Response to Comments

Project Name: Quality Auto Center
 Project File Number: PA22-005
 Review Completion: July 25, 2022

BY	REVISION
PJJ	New Pedestrian Entrance
	1

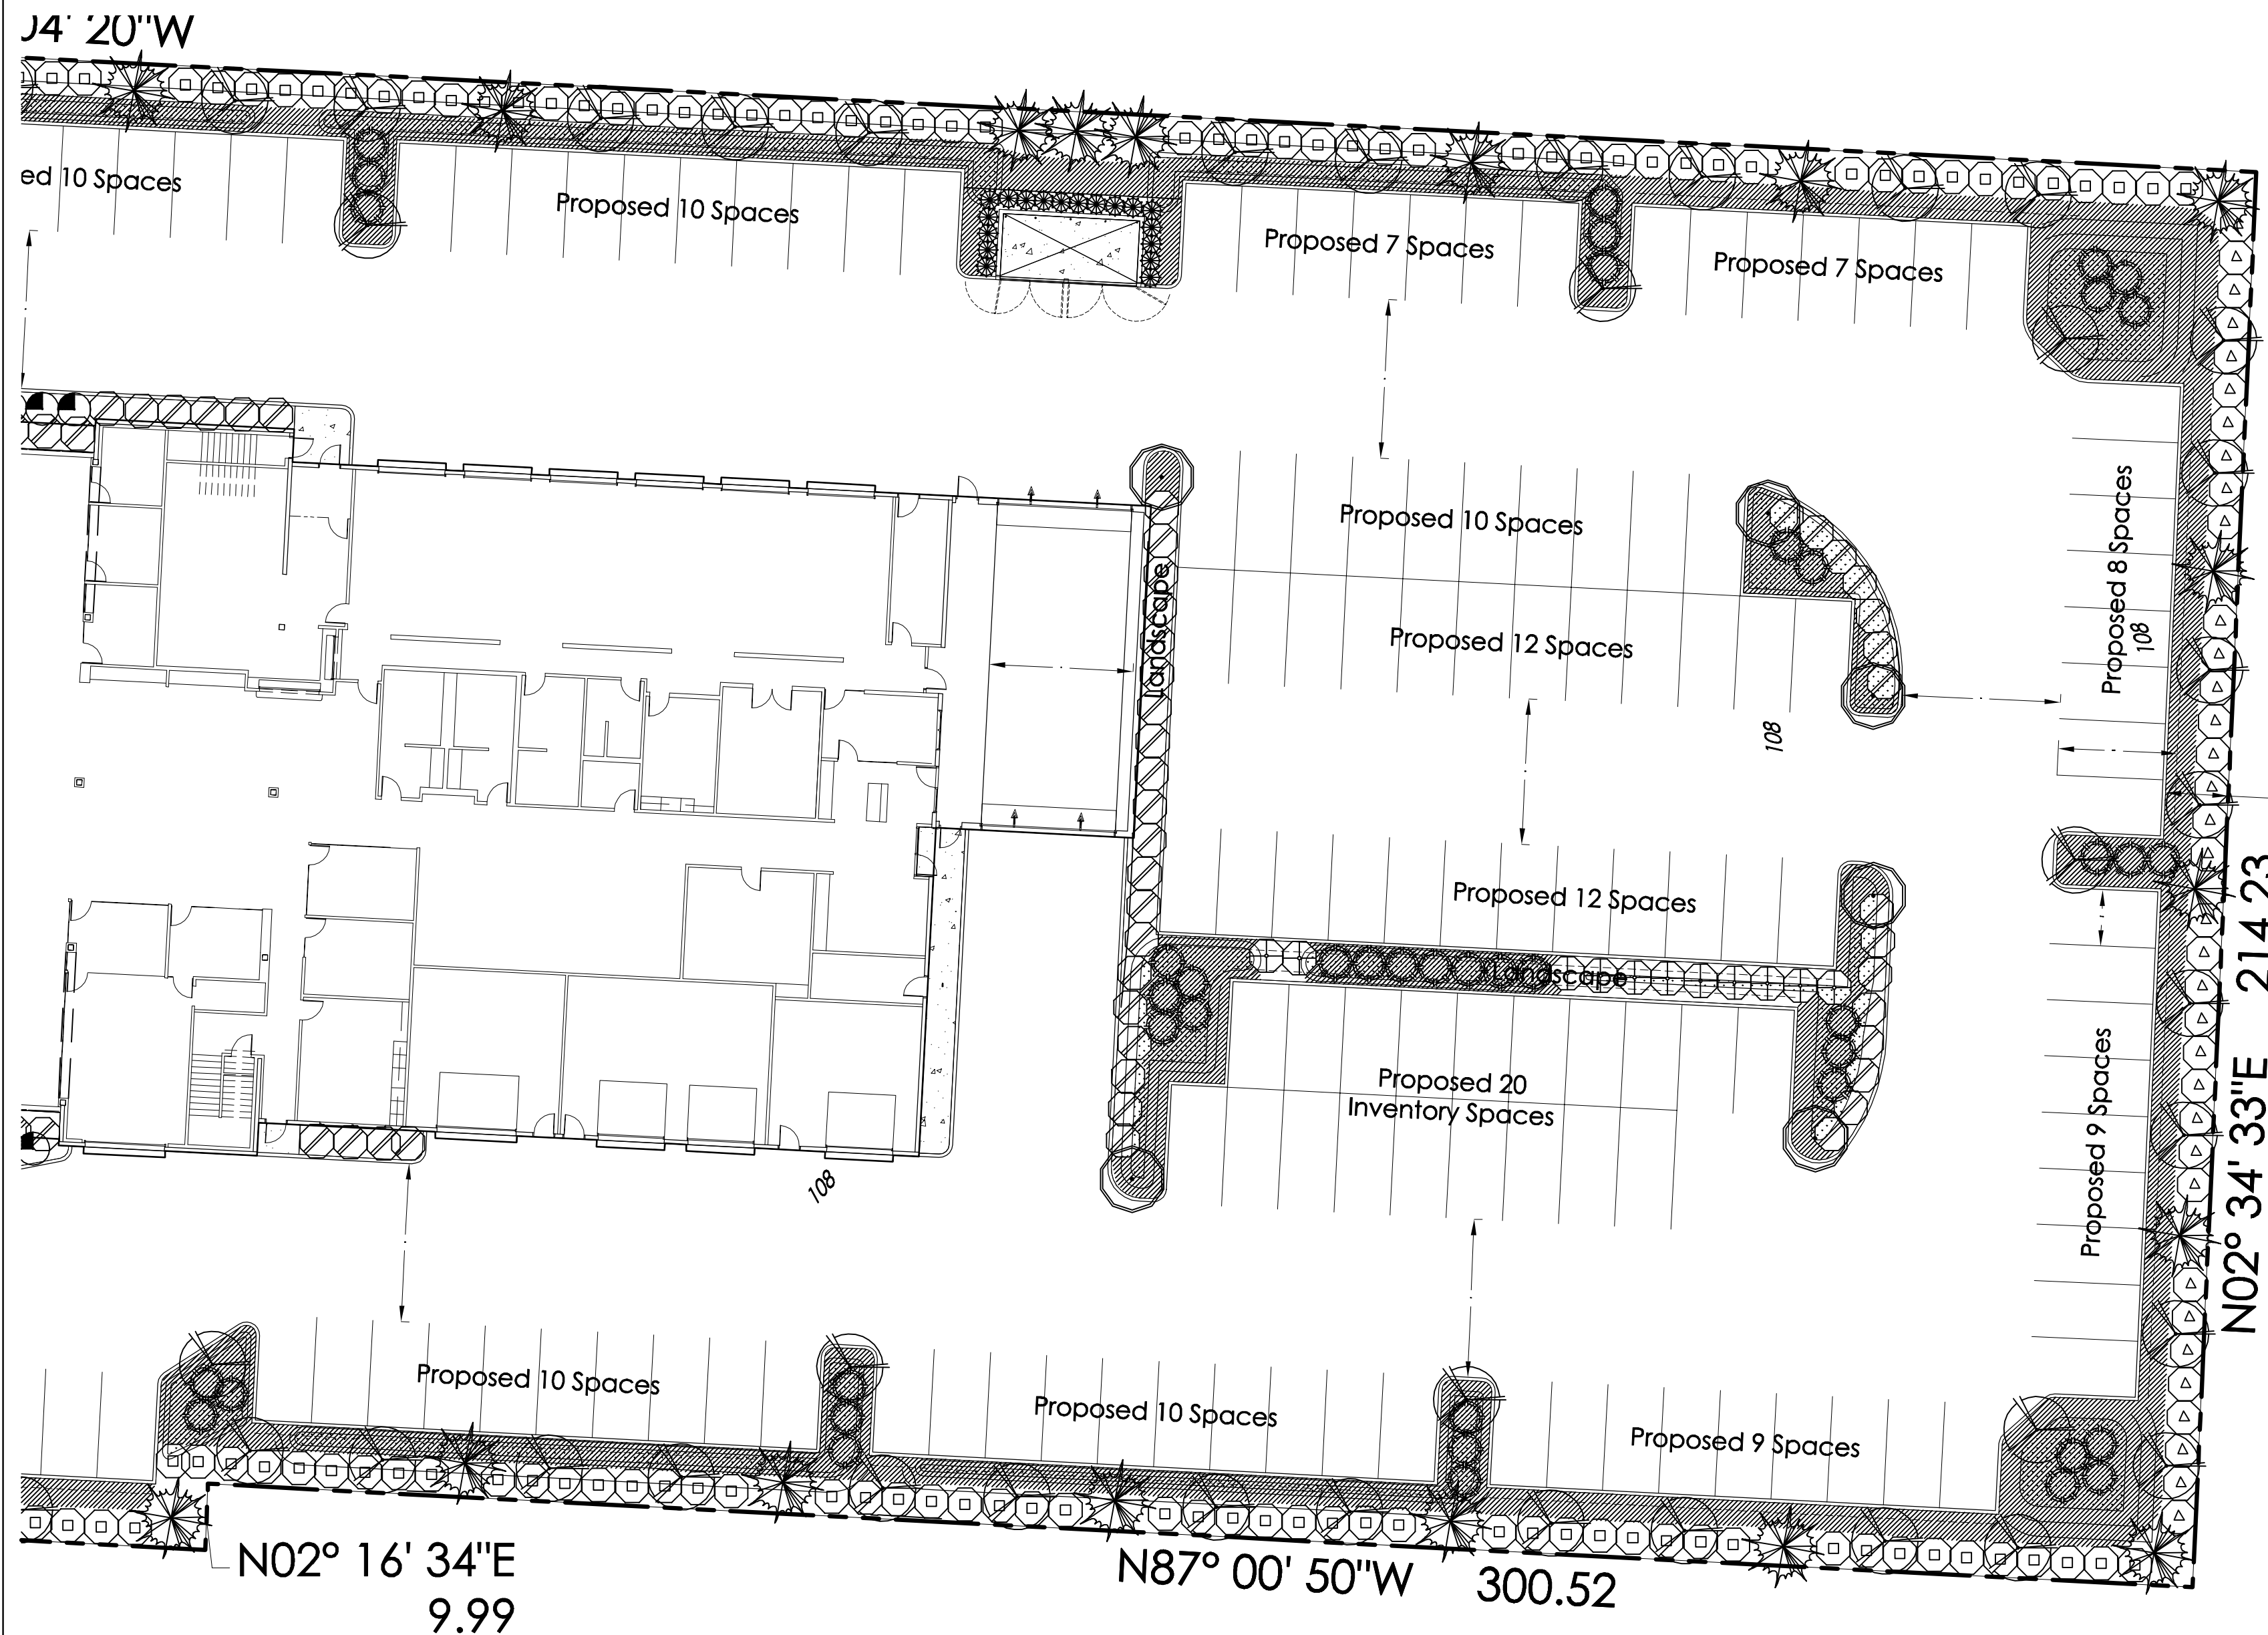
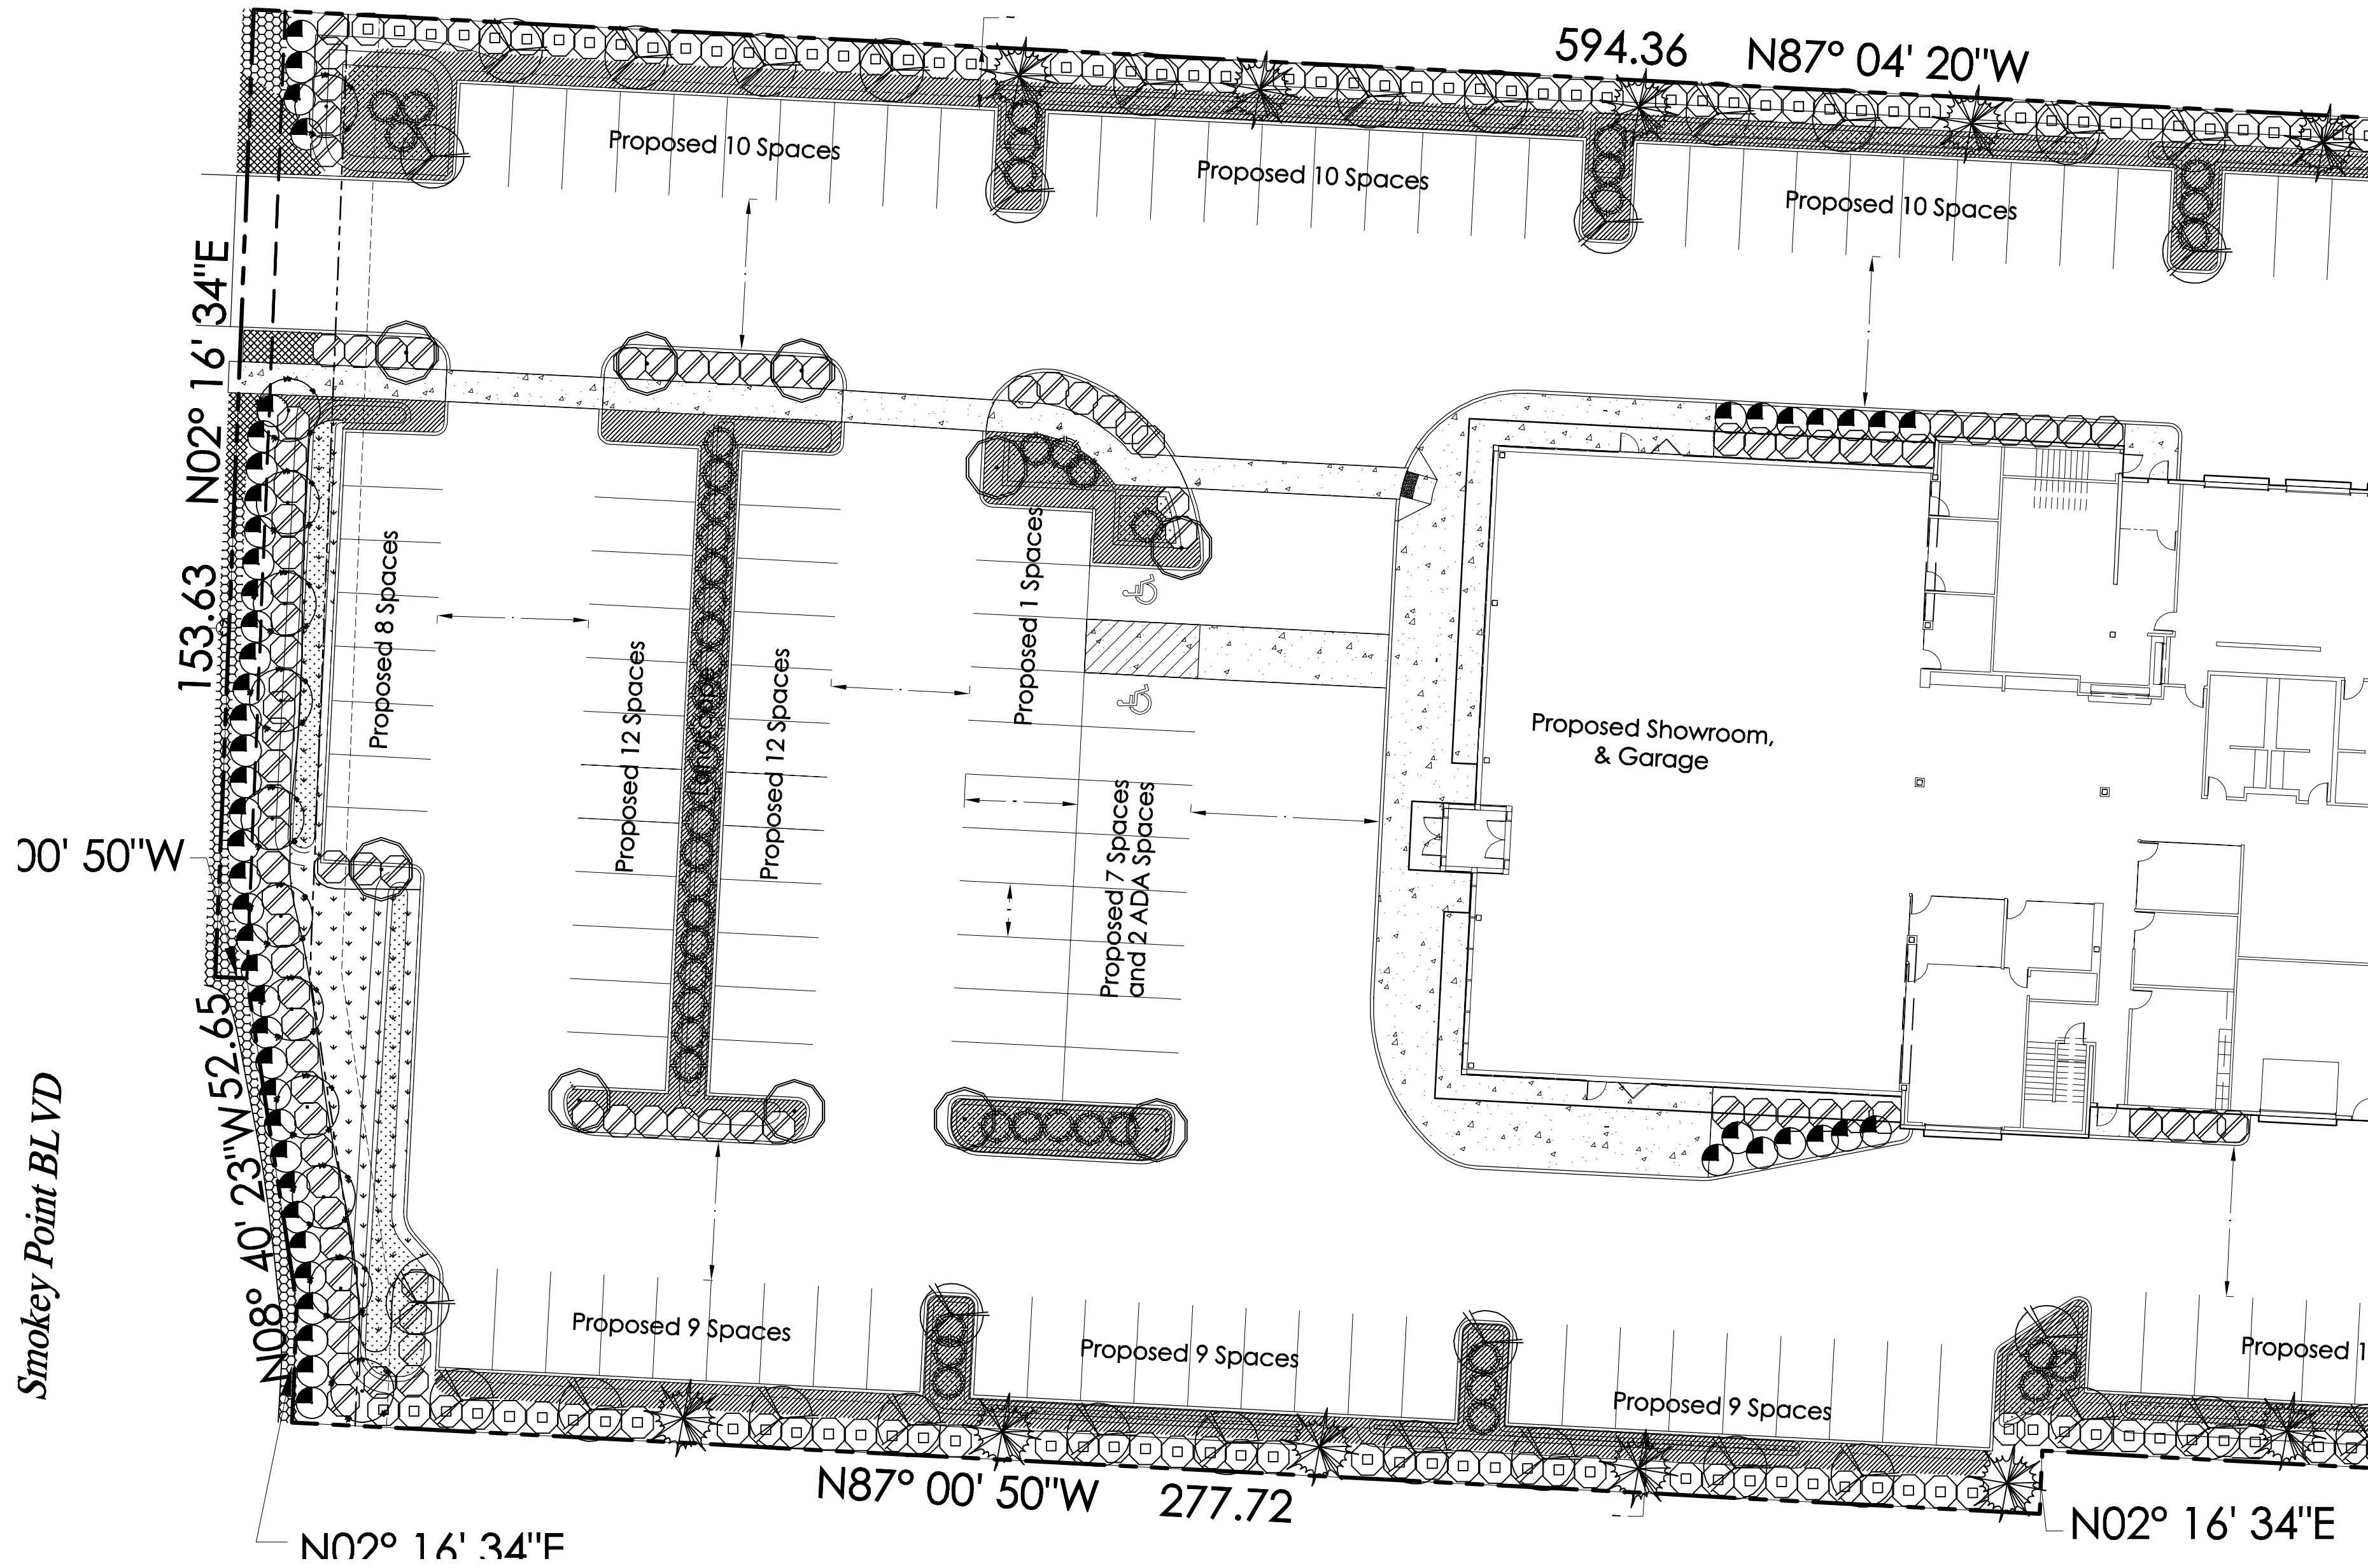
<p>2. Prior to civil construction plan approval, a detailed landscaping plan depicting all of the applicable elements outlined in MMC 22C.120.030 will be required to be approved. Below are specific design requirements outlined in MMC Chapter 22C.120 and in MMC 22C.020.250(4). Comments on the amended landscape plans will be provided during civil construction plan review, specifically related to number and type of plantings within required site buffers, parking lot islands, bioretention cells and enhanced landscaping along Smokey Point Boulevard.</p>	<p>Landscape plan has been updated and supplied with submittal consistent with pedestrian path update. Landscape Plans will seek approval for civil construction permits.</p>
<p>3. Pursuant to MMC 22C.130.050(3)(d), prior to civil construction plan approval, a parking lot illumination plan shall be approved, in accordance with the</p>	<p>Parking lot illumination plan will be provided prior to civil construction plan approval. Thank you.</p>
